PLANNING CONSULTATION RESPONSE

Application No	2026/0164
Proposal	Demolition of garages and erection of 2no. detached dwellings (Part Retrospective) (Amended Description).
Address	Garage Site Bmbc Asset Id B00286, Cresswell Street, Pogmoor, Barnsley
Date of Consultation Reply	17/04/2026
Consultee	Claire Wilson, Planning Ecologist

Existing site layout

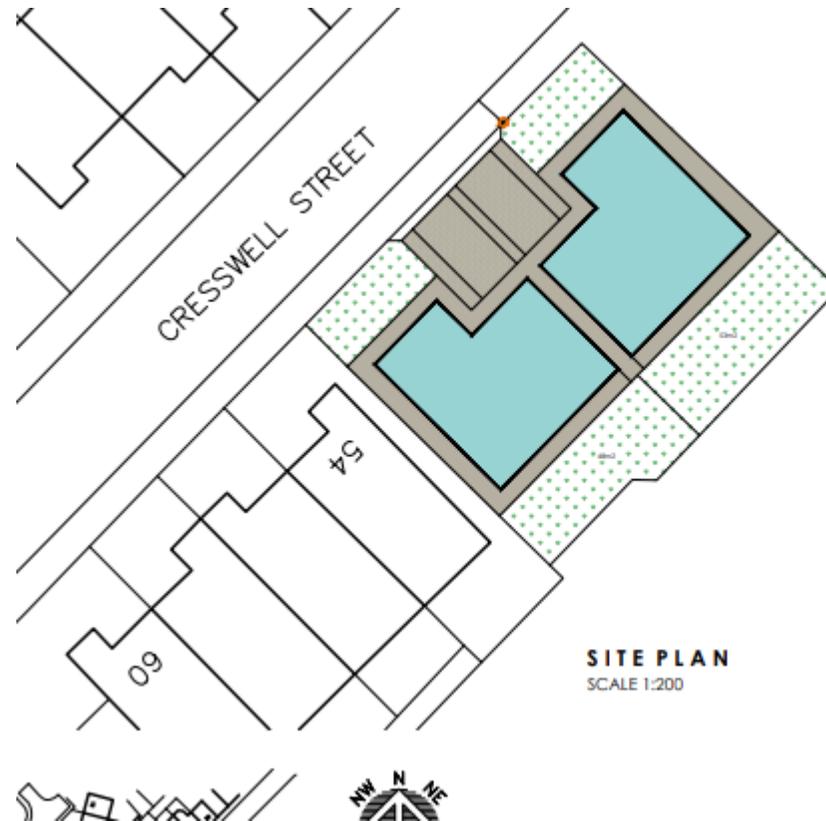
- Much of the site has been mapped as developed land, sealed surface. However, vegetation is present, therefore the habitat does not fit the UK Hab definition of developed land, sealed surface which states the following... *soil surface sealed with impervious material as a result of urban development and infrastructure*. The site appears to align with the definition of sparsely vegetated land. Therefore, the metric and report should be updated to include this. Condition assessments should also be provided.

- Paragraph 3.17 states that there is an area of vegetated garden on site, However, this has not been included on the habitat map.
- Photograph 2 appears to show an area of scrub yet this has not been included within the report or metric calculation - is this what has been mapped as vegetated garden? If so, it does not fit the definition of vegetated garden as it is not within a residential curtilage. I seek further clarification on this and a species list. Does this scrub also cover the area that is currently mapped as modified grassland?
